**From:**  
**Sent:** 11 September 2025 22:08  
**To:** DC Admin  
**Subject:** Planning Application 2025/62/92206/E

Objection to Planning Application 2025/62/92206/E- 42 Robin Royd Lane, Mirfield, WF14 0LG

Job No: 3115
 Drawing No: 004

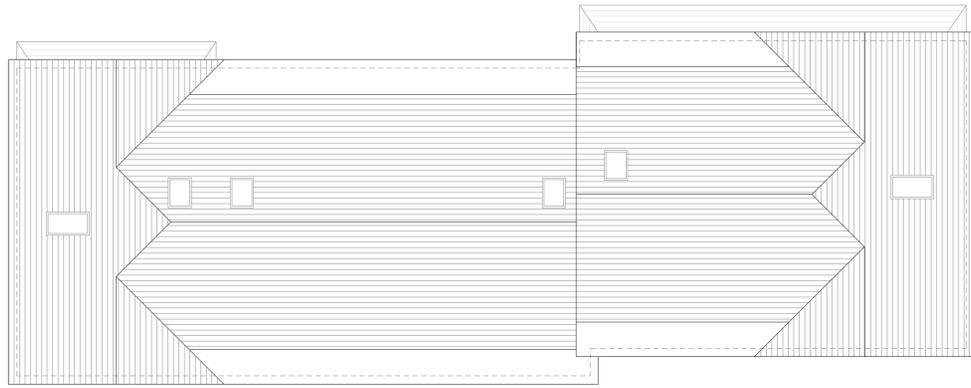
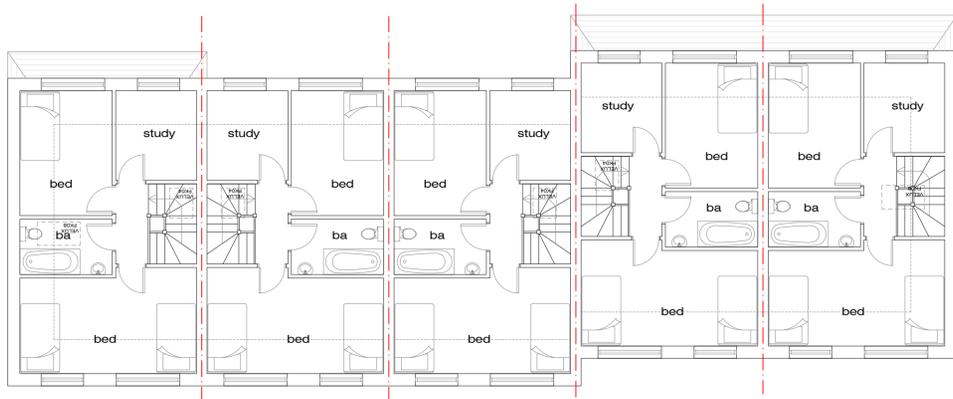
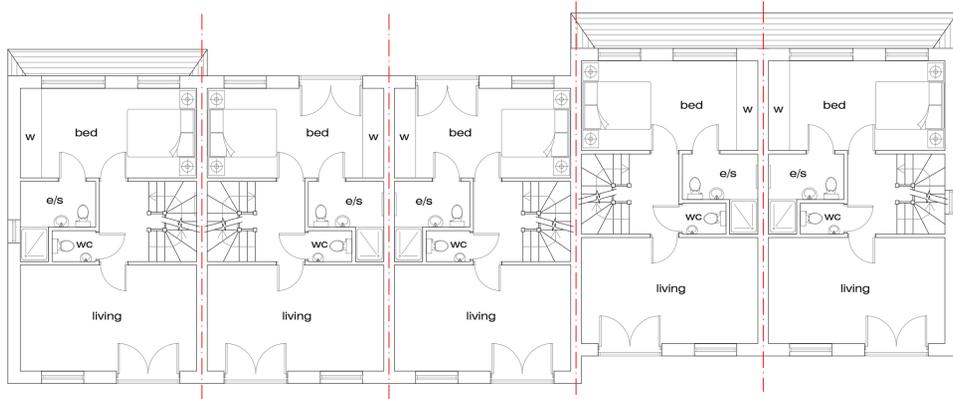
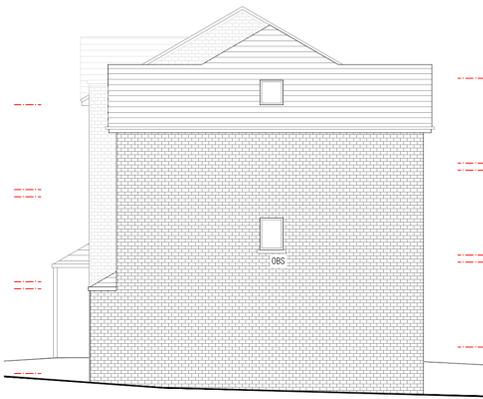
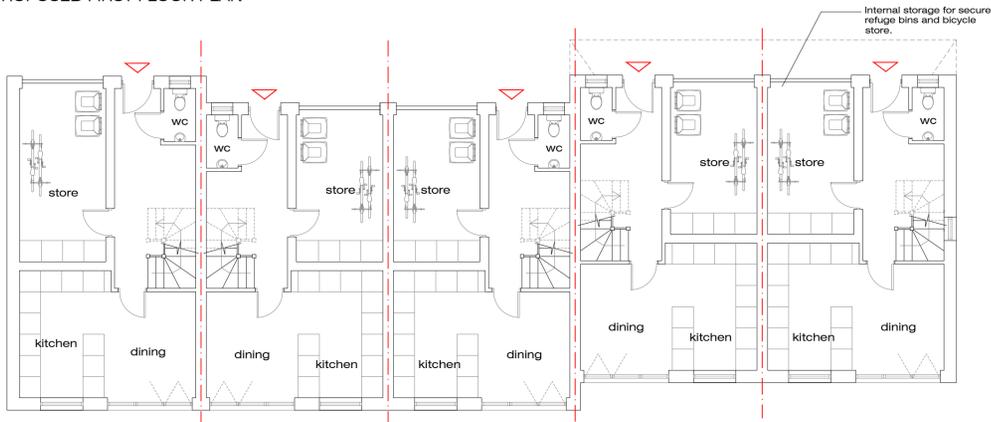
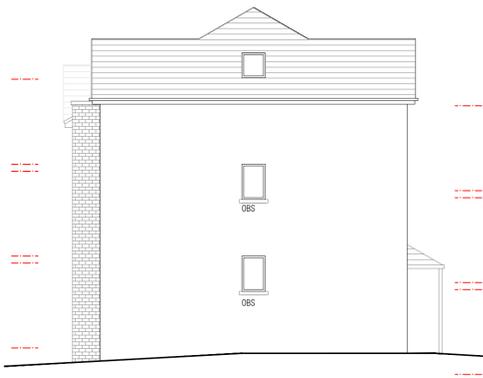
With reference to planning document 1102268, no consideration has been made for the windows of habitable rooms on our property and, after consulting our own architect, are reliably informed that the current proposed plans leave only about 18 meters from facade to facade which directly contravenes the national guidelines of 21- 22metres and article 7.19 of the Kirklees House Builders design guide, '21 metres between facing windows of habitable rooms at the back of dwellings.' This, coupled with the rear facing Juliette balconies on each property, and many windows overlooking properties on Wellhouse Lane is completely unacceptable.

While there is scope to move the whole block forward, thus allowing for the recommended distance of 21- 22 meters at the rear, we believe this would then pose an issue with the parking designation for 2 vehicles as required on a 3 bedroom property. As there is no on street parking available due to the proposed design, this solution would result in a loss of viable and adequate parking, directly contravening policy LP22.

The proposed properties are marketed as 3 bed, 2 of which are double rooms, but with the 'study' to the second floor and the 'storeroom' to the ground floor there is potential for both rooms to, very easily be converted into further bedrooms increasing the likelihood of more adults and subsequently more vehicles. The current plan proposal would also cause issues should new homeowners wish to extend in a few years, which is a very likely possibility. The rear garden spaces only being around 8.8 meters, a permitted development of 3 meters to the rear would leave only a distance of 5.8 meters to the boundary wall and further impeding on our privacy.

The land directly behind the site, to the south east, directly beyond and leading up to the existing dry stone wall is private land to which the proposed properties have no legal access. The agent has not served mandatory land ownership certificates rendering the proposed gates illegal (reference planning document; 1099406, proposed landscaping and 1099401, proposed site / block layout). We therefore must insist that all plans for gateways through the dry stone wall and giving access to the rear gardens of the proposed development be removed and request that notes be made on the deeds of any property that is developed on this land highlighting this fact so that there is less potential for any problems arising with future homeowners wanting to put in their own gates.

With the gates omitted, the middle terraces will have no access to the rear private space other than through the property itself.

We do not agree that the development is sensitive to or in keeping with the already established and varied styles that exist surrounding the site. All properties built in the last century are 1-2 storeys, given the proposed style of red brick and render we believe the development will not only feel intrusive and block light for many surrounding neighbours but stand out visually offensively from the surrounding architecture, resembling a modern apartment complex with many windows and Juliette balconies and thus contravening LP24(a).
